EIS RESPONSE**NEW MAITLAND HOSPITAL**14th August 2018

Revision C

GANSW – Request for further information on how the building envelope was developed, including options analysis and why the final proposal was chosen.

## 4-1 MASTER SITE PLAN

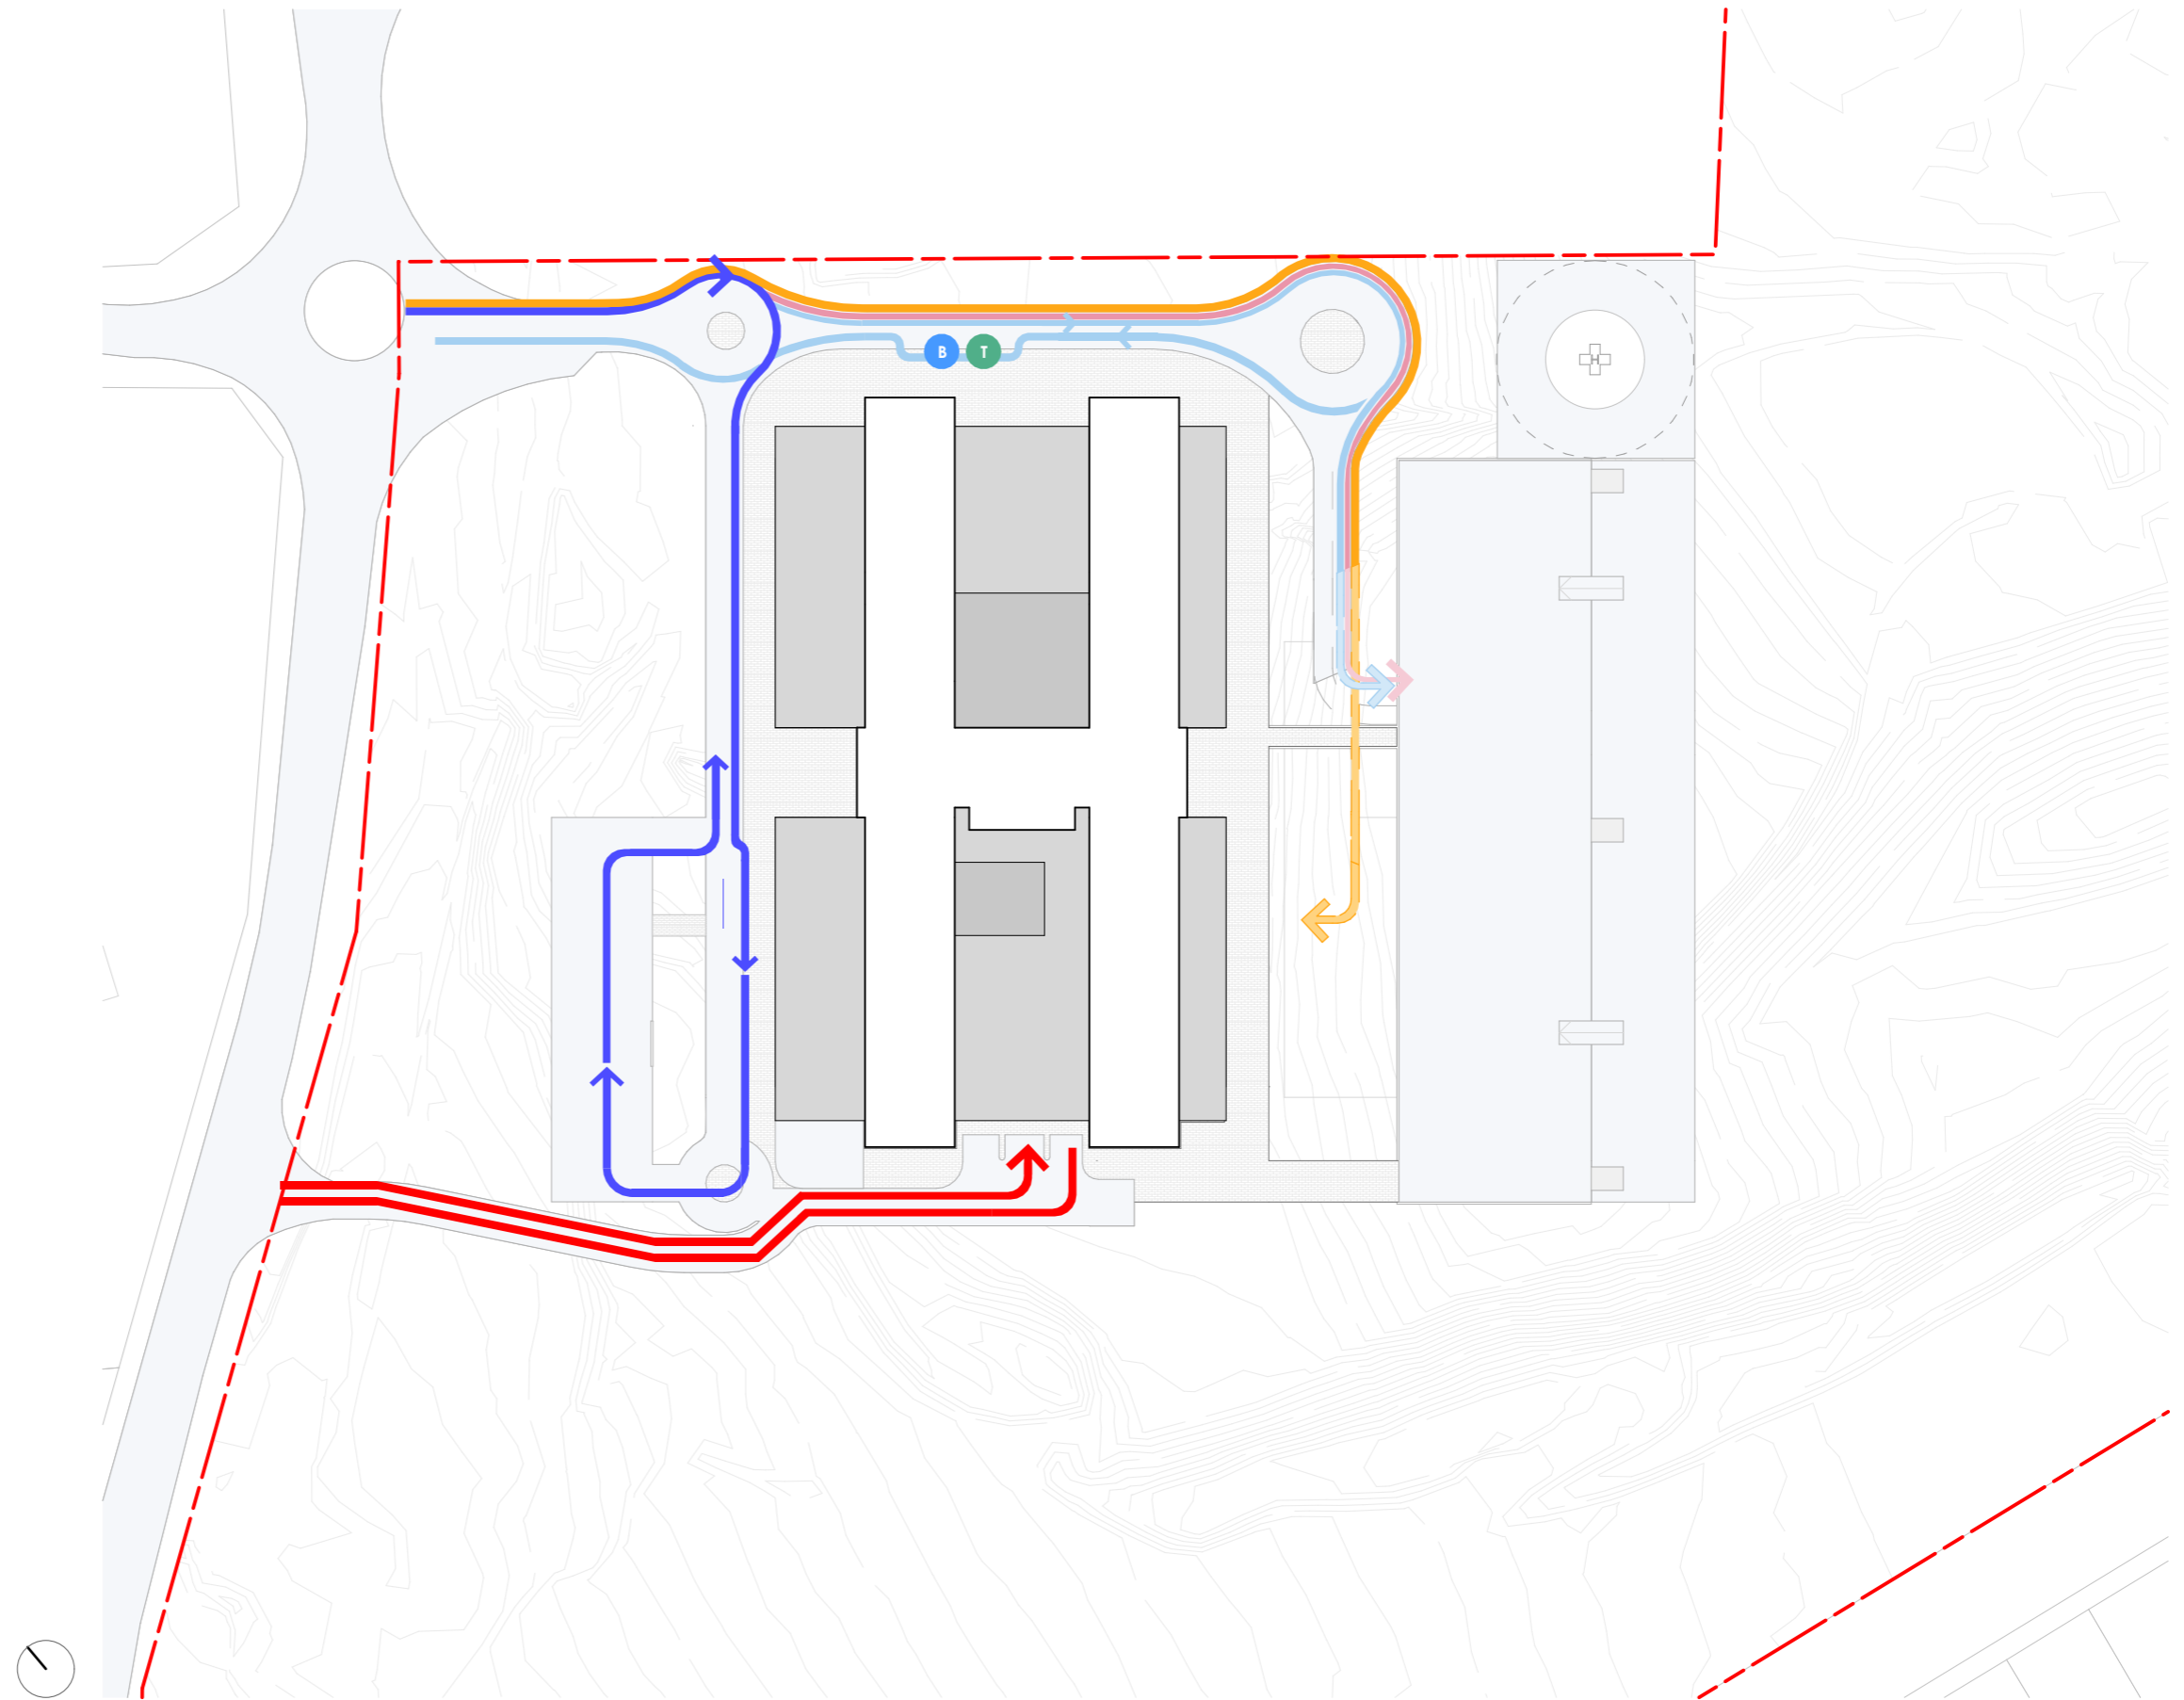
GANSW – Recommendation that the proponent prepares a detailed landscape plan which demonstrates how; a) the natural setting will be incorporated, b) landscaping will be integrated with car parking areas to break down their impact, and c) patients, staff and visitors will be able to enjoy easy and direct connections between the hospital building and landscaped areas.

FP RESPONSE – The Landscape Zonal Plan (DA-08) identifies an extensive area of natural and regenerated bushland as well as new landscaped zones surrounding the hospital building that will reduce the visual impact of the building and car parking areas and provide important amenity for patients, staff and visitors. A detailed landscape strategy will be provided in the Stage 2 planning submission providing further detail on the items listed above by GANSW.

We note the current design incorporates the following:

- + extensive new landscaped zones around the hospital, in particular to the west and south providing zones for recreation, relaxation and contemplation away from the busy areas of the hospital
